Rezoning Transportation Analysis

Petition Number: 2023-031

Revision Log:

| Date | Description |
|---------|--------------------|
| 7-26-23 | First Review (PDM) |

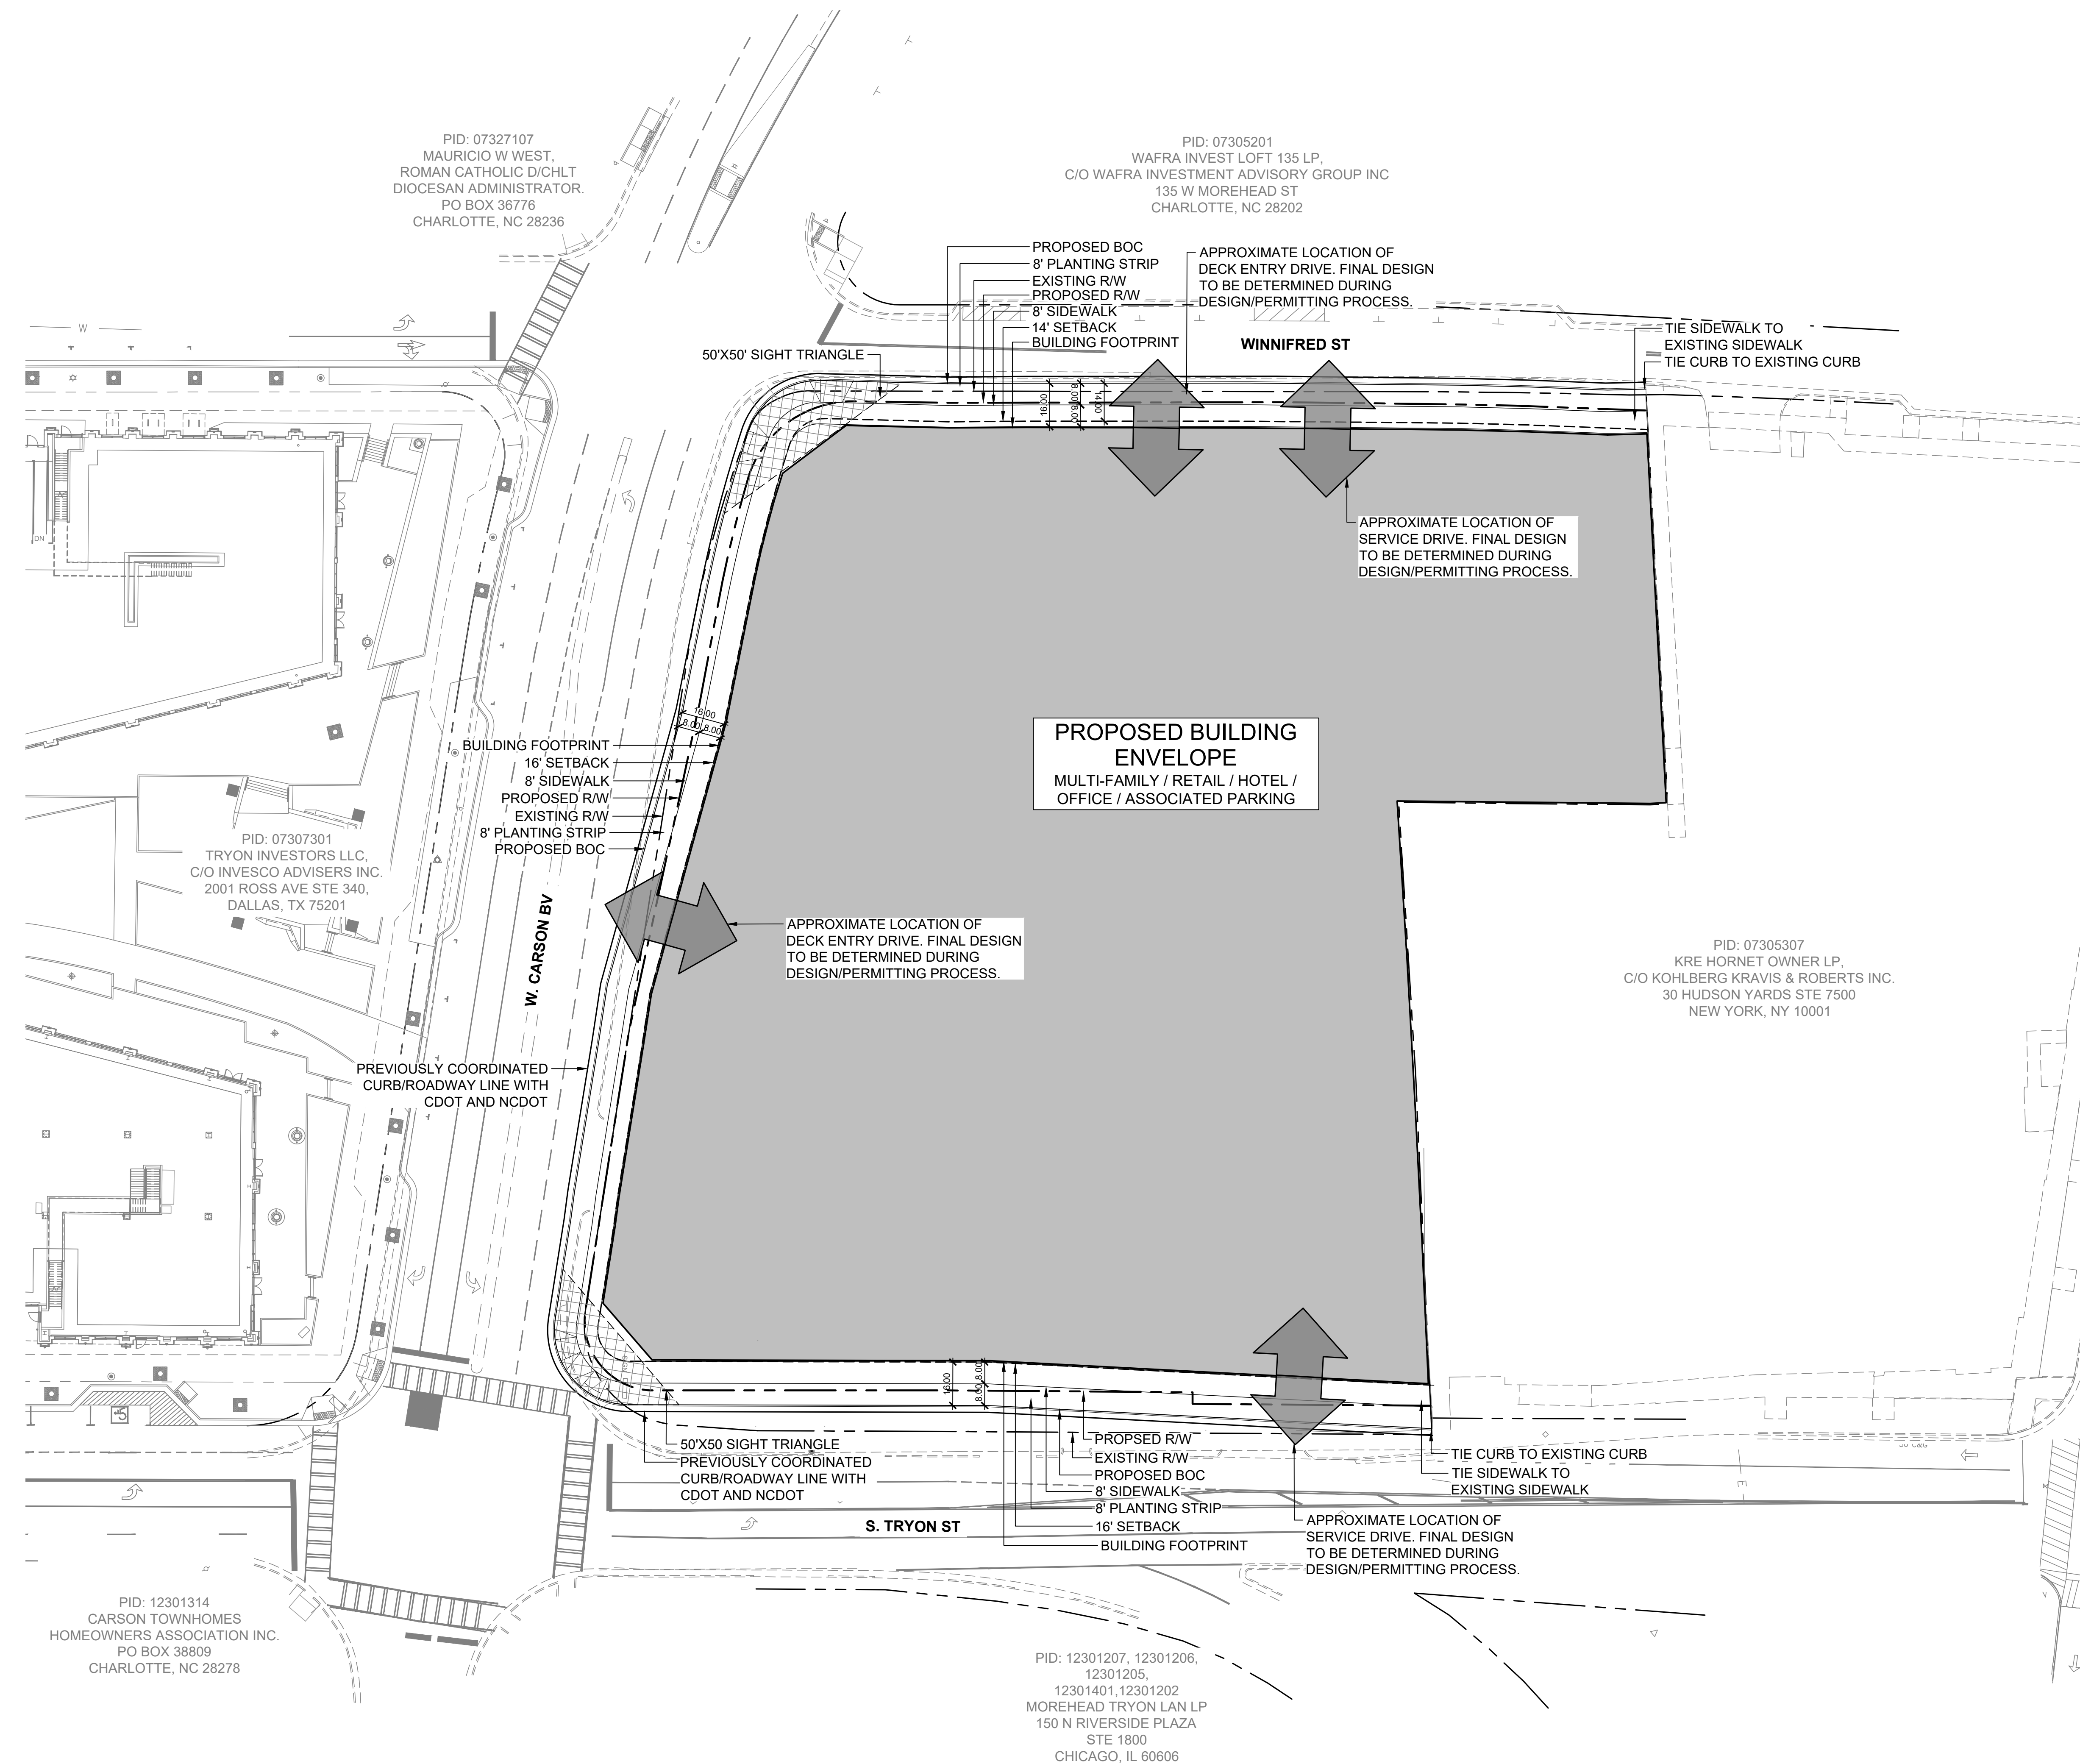
Label and dimension the curb and gutter from the centerline for each road on the site plan.

3. Revise site plan to dimension the curb lines and right-of-way for each public road from the roadway centerline.
4. Revise site plan to restrict access South Tryon Street and East Carson Boulevard to right-in / right-out.
5. Revise site plan and conditional notes to show how and where the proposed maneuvering within the setback will occur. Additional comments may be provided by CDOT based on proposed maneuvering plan once more information is provided.
6. Revise site plan and conditional notes to provide clarity to the proposed phasing plan. Site plan should show the limits of each phase.
